**Consultation Response from KC,
Highways Development Management**

2023/91907 rear of, 18, Kingsley Avenue, Lockwood, Huddersfield, HD1 3SR

Demolition of dwelling to create access and erection of 10 dwellings

Date Responded:01/09/2023

Title: **Proposed Foul and Surface Water Drainage Strategy**

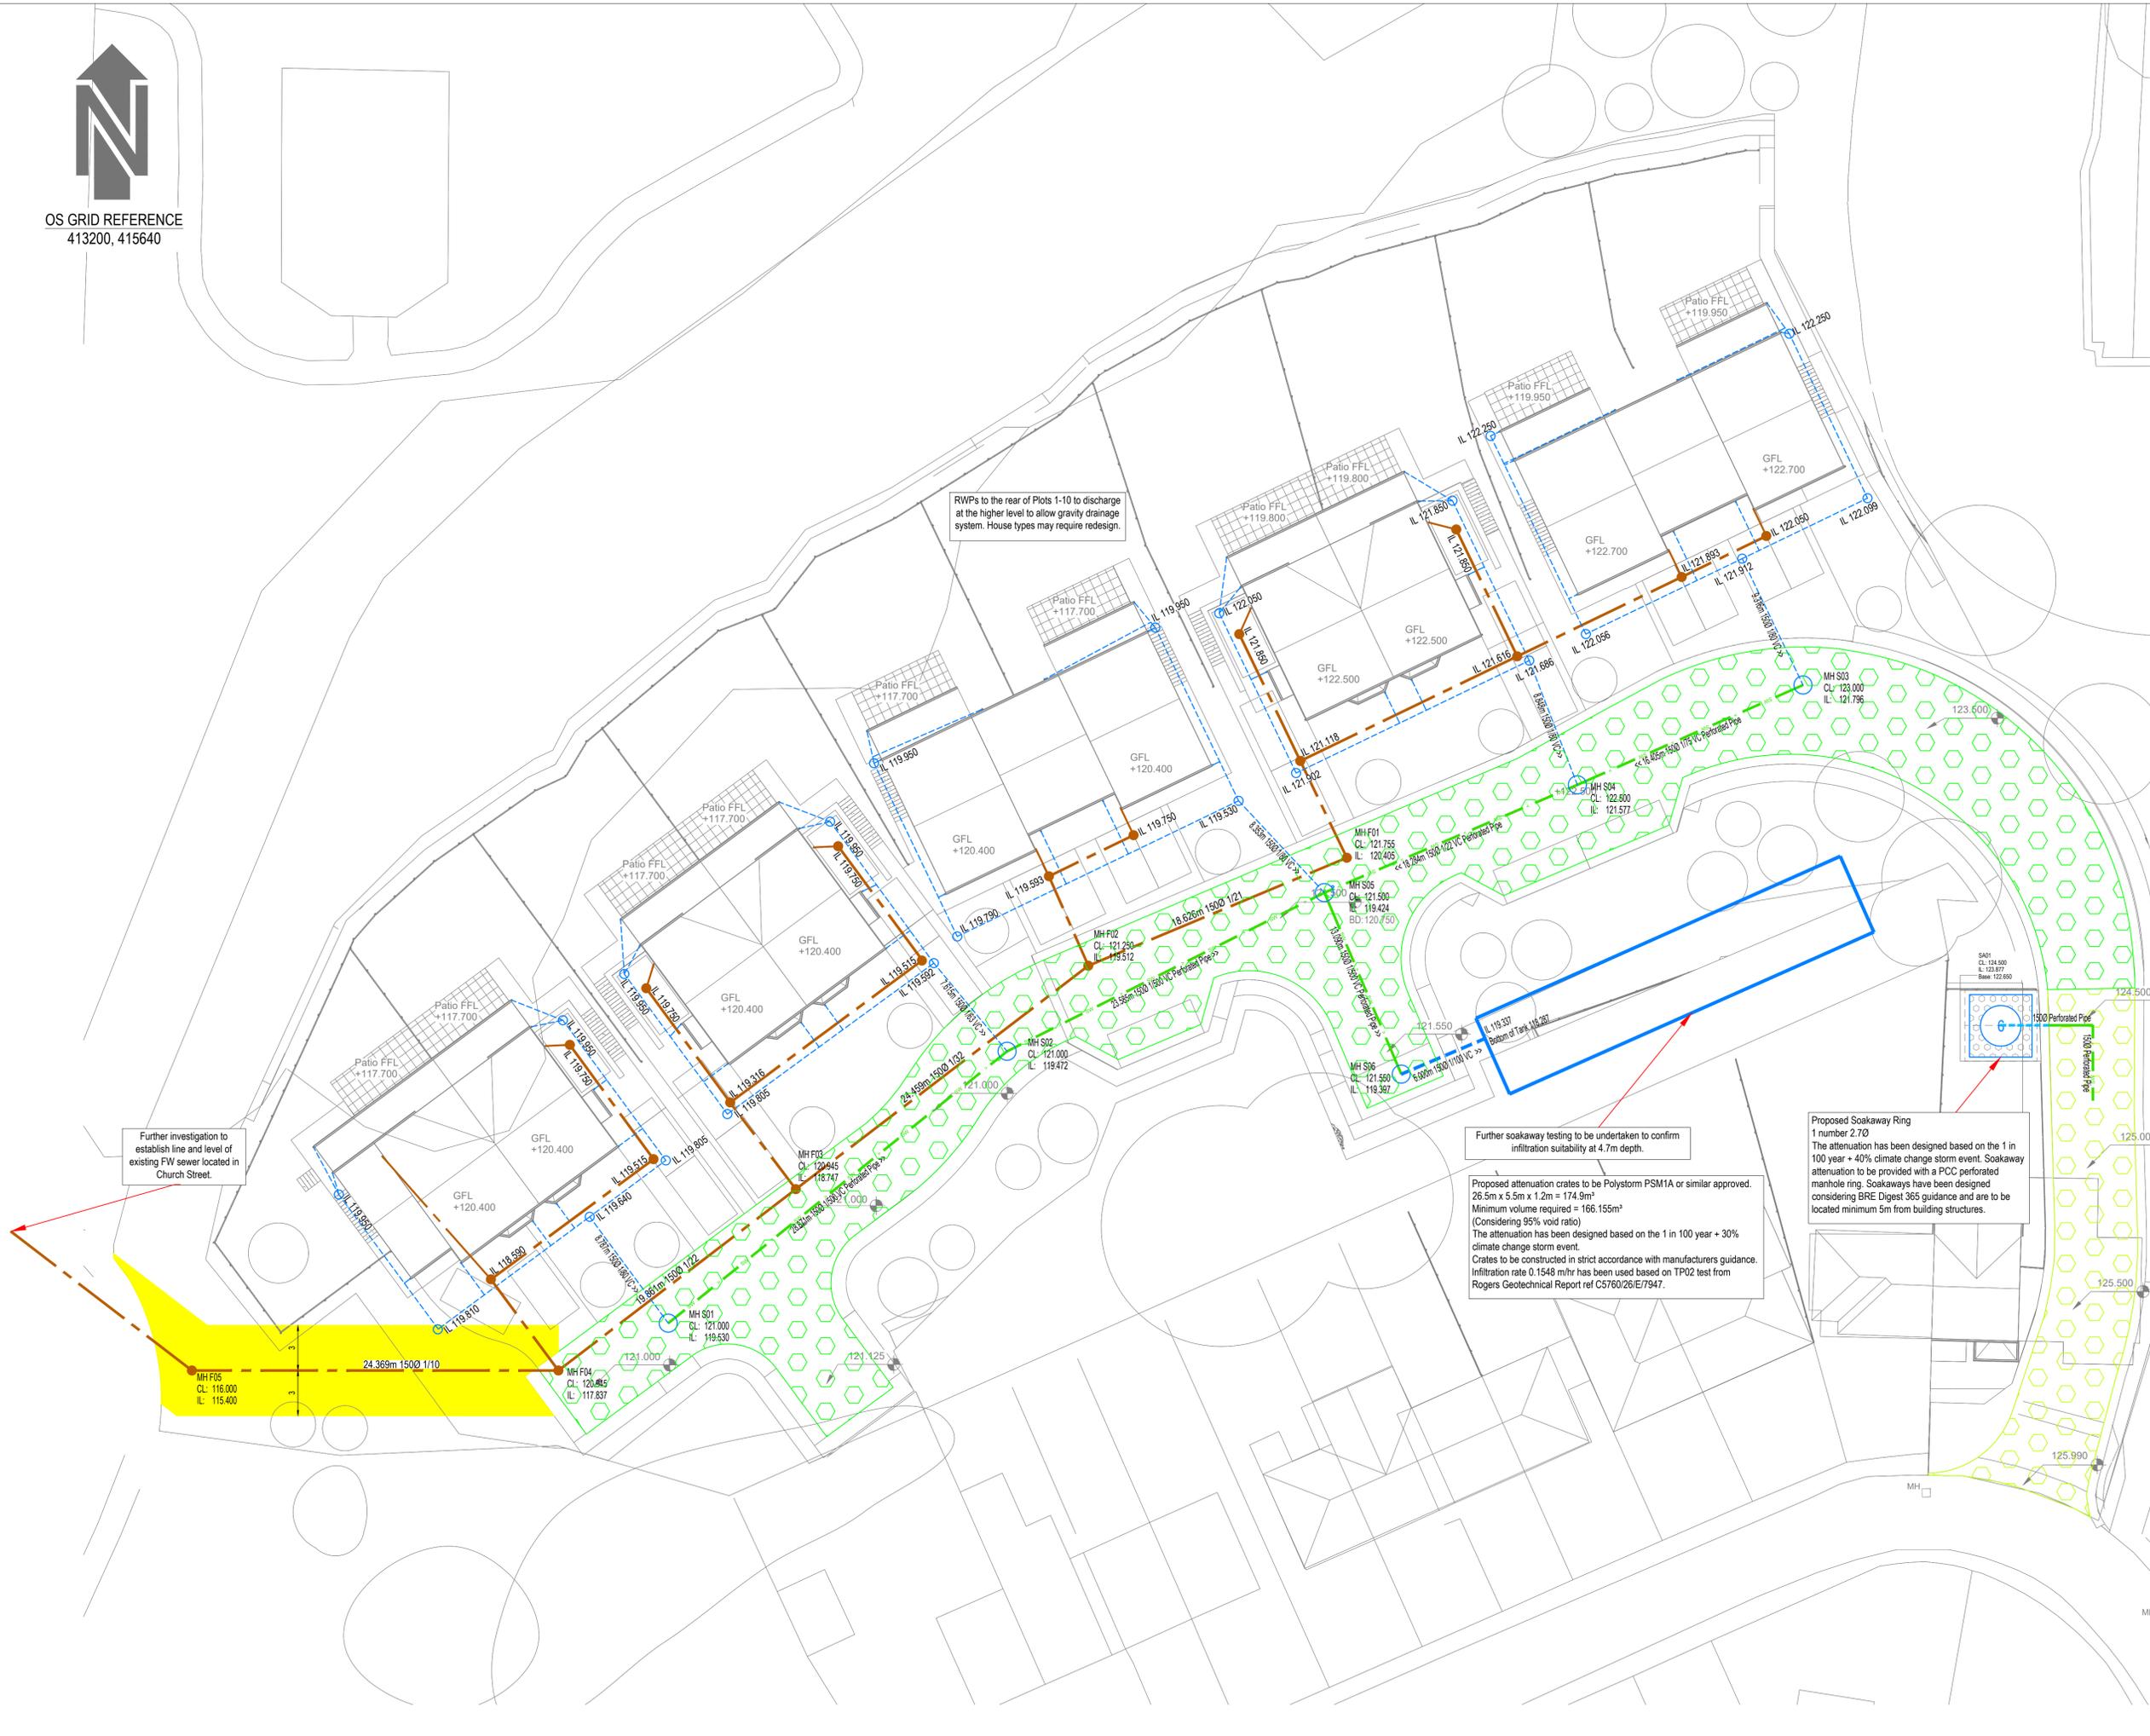
Suitable visibility splays of 2.4m x 43m should be achievable and demonstrated accordingly, the junction needs to be designed to an adoptable standard having a minimum kerbed radius of 6.0m. the current arrangement is not considered acceptable for adoption purposes.

There appears to be conflict with the existing parking provision

The internal arrangements should accord with the Councils Supplementary Planning Document – Highway Design Guide. The current proposal indicates a shared surface from the site access throughout to plot no 5, gradients for less than 1:20 should have a segregated footway so is considered unacceptable for adoption in its current form.

A hard margin of 0.6m from plot 6 adjacent to the dwellings should be provided.

Forward visibility on internal road layout bends to a design speed of 23mph and be achievable within the highway boundary and not across third party land.

Refuse storage and collection arrangements should be demonstrated and be in accordance with Local Plan Policy LP24 part d(vi). Swept paths for an 11.85m refuse collection vehicle are required
